**KIRKLEES METROPOLITAN COUNCIL
INVESTMENT & REGENERATION SERVICE**

DELEGATED DECISION TO DETERMINE PLANNING APPLICATIONS

Reference No:	2024/62/92896/E
Site Address:	26, Lees Avenue, Thornhill Lees, Dewsbury, WF12 0AN
Description:	Erection of two storey and single storey extensions to front, side and rear
Recommending Officer:	Jennifer Booth

DECISION - REFUSED

Drawing No.	Revision
A104

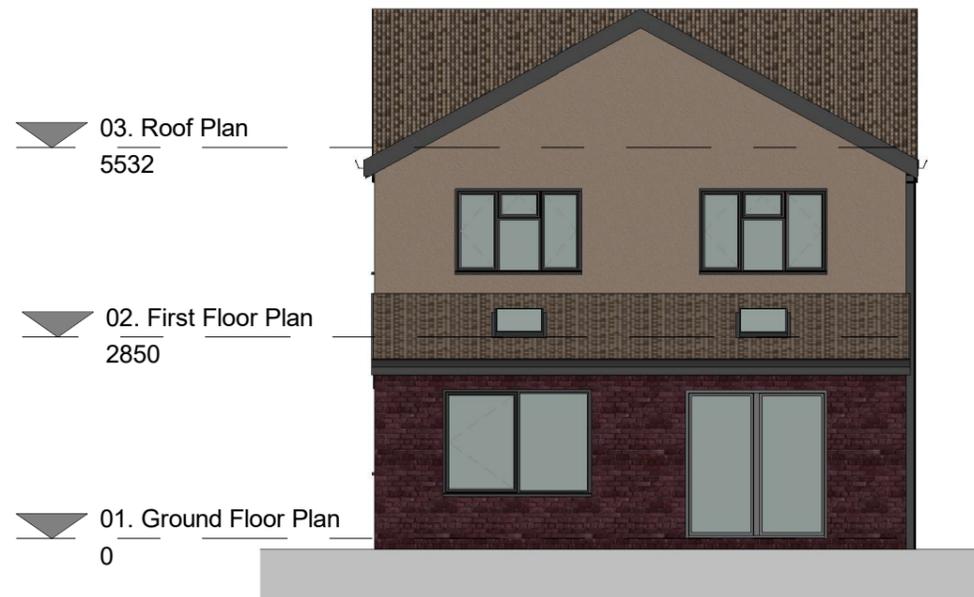
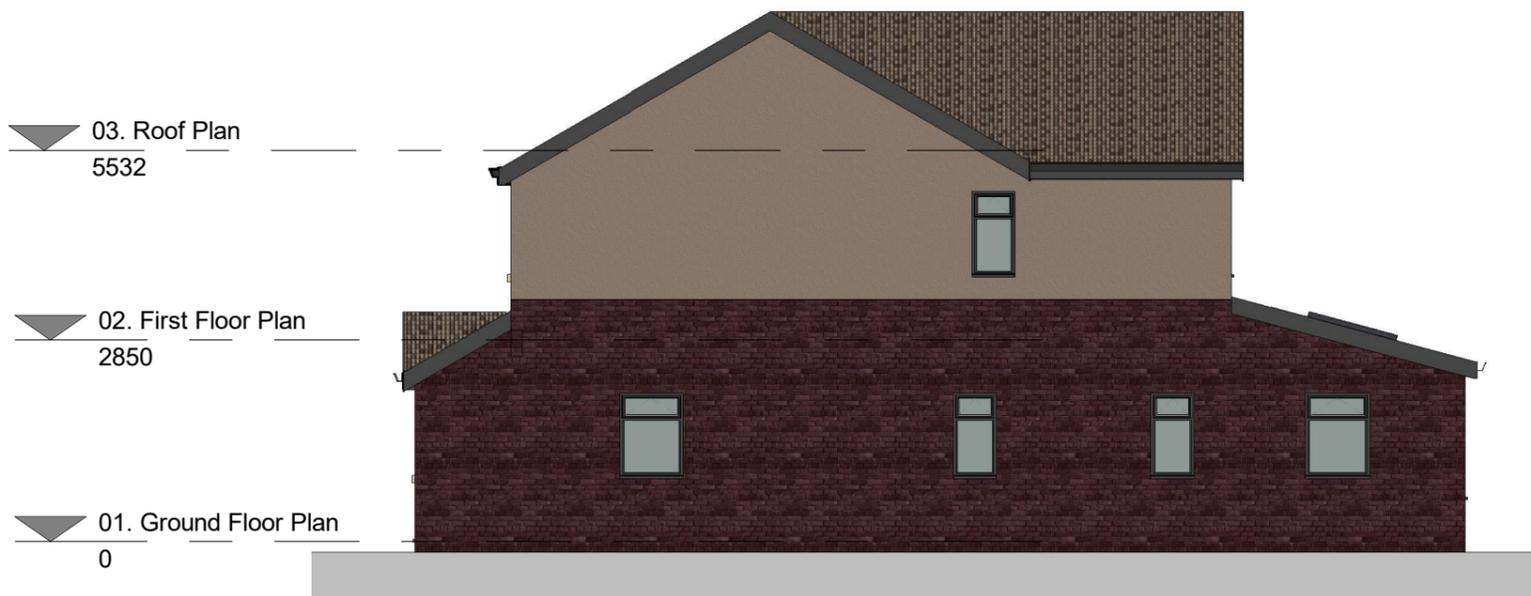
The side extension would not be set back from the front elevation and would include alterations to the existing hipped roof form to form a gable with no gap to the boundary. As such, the extension, although limited in terms of its projection, would not allow the original house to remain the dominant feature and would therefore lack subservience and would alter the sense of space between the properties. Although it is noted that the material proposed would match the main house, the overall design would not be acceptable in terms of visual amenity.

The development proposals would cumulatively result in harm to the visual amenity of the host dwelling and character of the area, contrary to Policy LP24 of the Kirklees Local Plan (a) in terms of the form, scale and layout and (c) as the extension would form a subservient addition to the property in keeping with the existing building, KDP 1 & 2 of the House Extensions & Alterations SPD and the aims of chapter 12 of the National Planning Policy Framework.

The proposed side extension, by reason of its design, width and spatial relationship with the boundary, when viewed with the proposed front extension, would form an extension which is not subservient and would diminish the existing space between the properties to form an incongruous feature. To permit the proposals would be contrary to Policy LP24 of the Kirklees Local Plan, KDP1 & KDP2 of the House Extensions & Alterations SPD and advice within Chapter 12 of the National Planning Policy Framework.

The proposed extensions to the front, side & rear of the property, given the cumulative appearance, would not form subservient additions to the property thereby detracting from the character of the host and wider area. To permit the proposals would be contrary to Policy LP24 of the Kirklees Local Plan, KDP1 & KDP2 of the House Extensions & Alterations SPD and Chapter 12 of the National Planning Policy Framework.

Drawing No.	Revision
A103

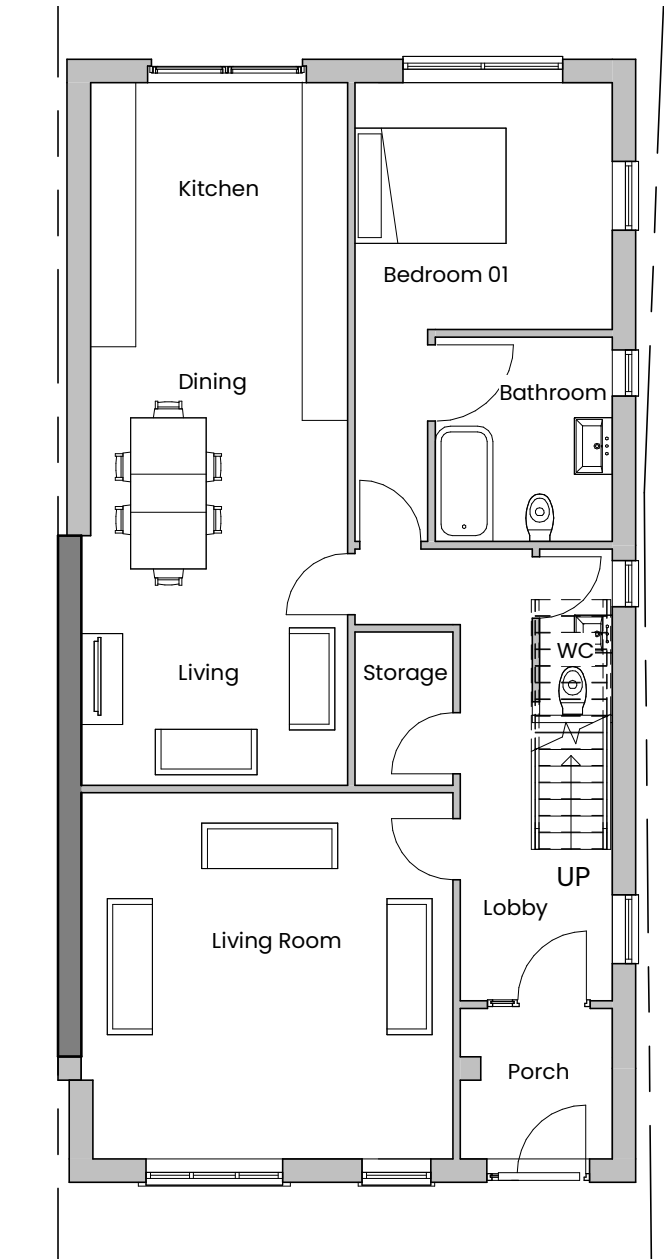
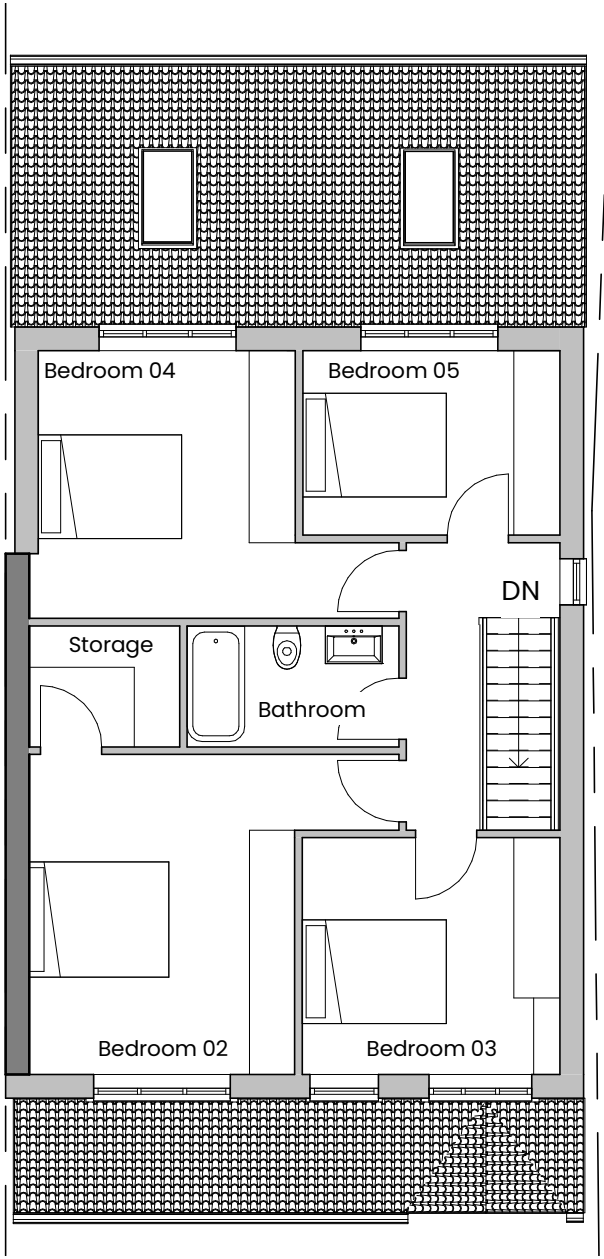
The proposal includes a significant ground floor extension across the full width of the dwelling with a projection of 6m. The first floor extension would have a lesser projection of 3m. There are no similar extensions in the area and as such this would be out of character with the wider area. It is noted however, that the property has a large rear garden, and a reasonable amenity space would be retained. Furthermore, the materials proposed would match the main house and the detailing is considered to be appropriate. The rear extensions are therefore considered to be justifiable in terms of visual amenity.

The rear extension would be constructed along the shared boundary with the adjoining dwelling. The projection of 6.5m along the boundary, all be it single storey, would have an overbearing and oppressive impact on the amenities of the neighbouring property. There are no mitigating factors on or around the site to justify this impact. Furthermore, the first floor extension with a projection of 3m across the full width of the drilling would infringe upon the 45° line from the neighbour's window on the boundary thereby resulting in an overbearing and oppressive impact. It is appreciated that there are no windows on the side elevation and that the windows proposed in the rear elevation would look into the applicant's own amenity space and as such there are no concerns in terms of privacy.

The proposed rear extension, by reason of its position along the boundary with the adjoining 28 Lees Avenue would result in an overbearing impact. To permit the proposals would be contrary to Policy LP24 of the Kirklees Local Plan, KDP5 of the House Extensions & Alterations SPD and Chapter 12 of the National Planning Policy Framework.
